Date: 04 February 2022
Our ref: 62049/01/IAN/AVi/20636775v1
Your ref: PP-11010676

Wendlebury Road, Chesterton: Bicester Gateway - Application under Section 96a of the Town and Country Planning Act (1990) to amend application ref. 19/01740/HYBRID

ELEVATION 2 - SOUTH EAST 'REAR' ELEVATION

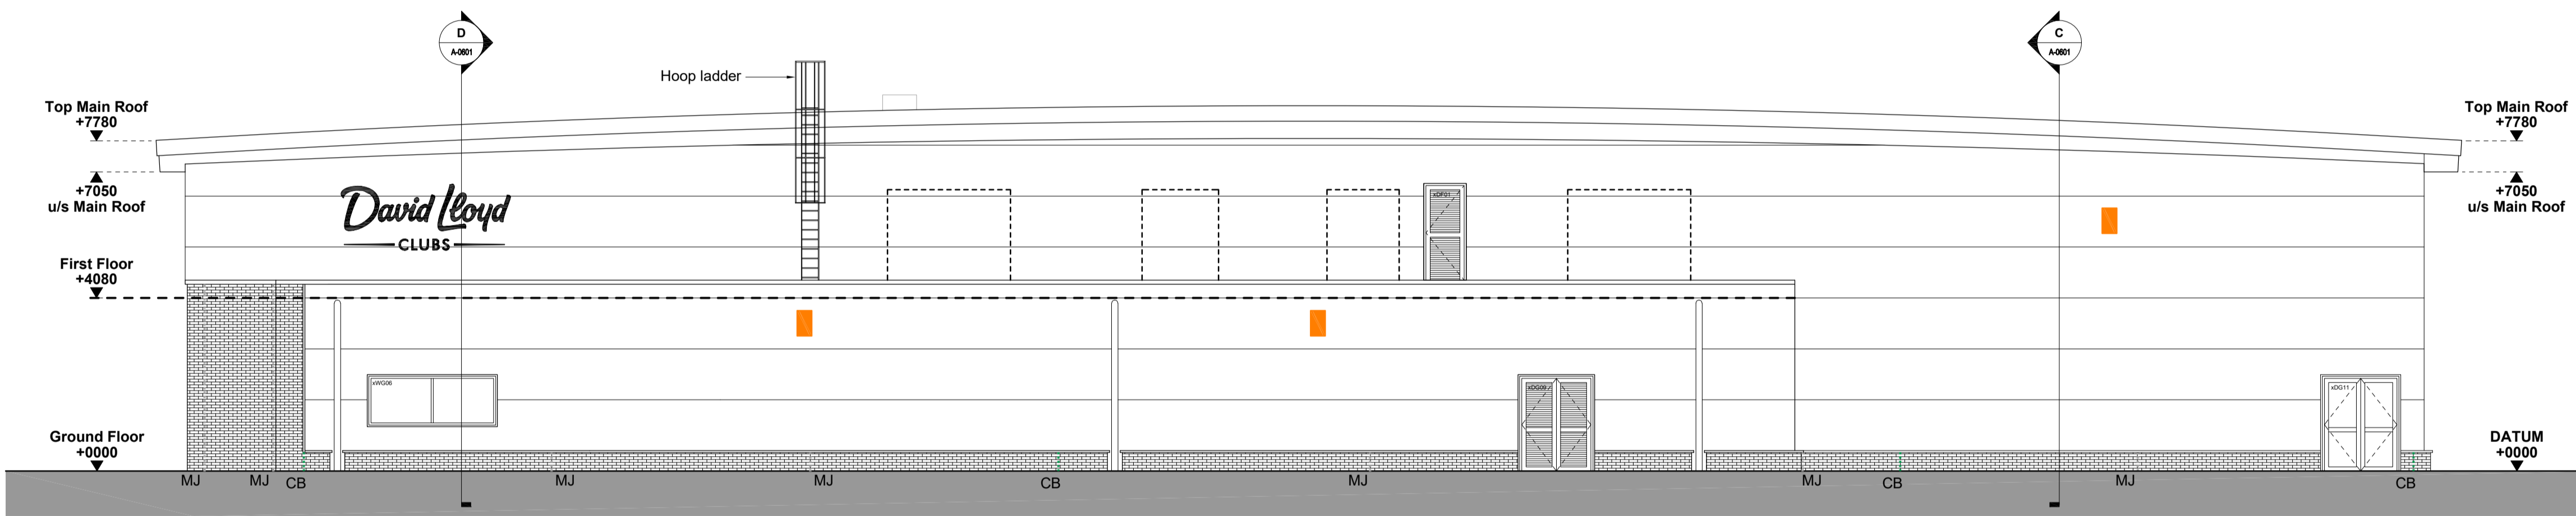
The proposed Non-Material Amendment will introduce a Cat Ladder on the south east rear elevation of the consented David Lloyd building and is for the purposes of servicing and maintaining the roof. The enclosed proposed Hoop Ladder elevation drawing (ref. 2018-260-A-PL-05-040) shows the discreet ladder and how it does not materially alter the approved building or its visual effects.
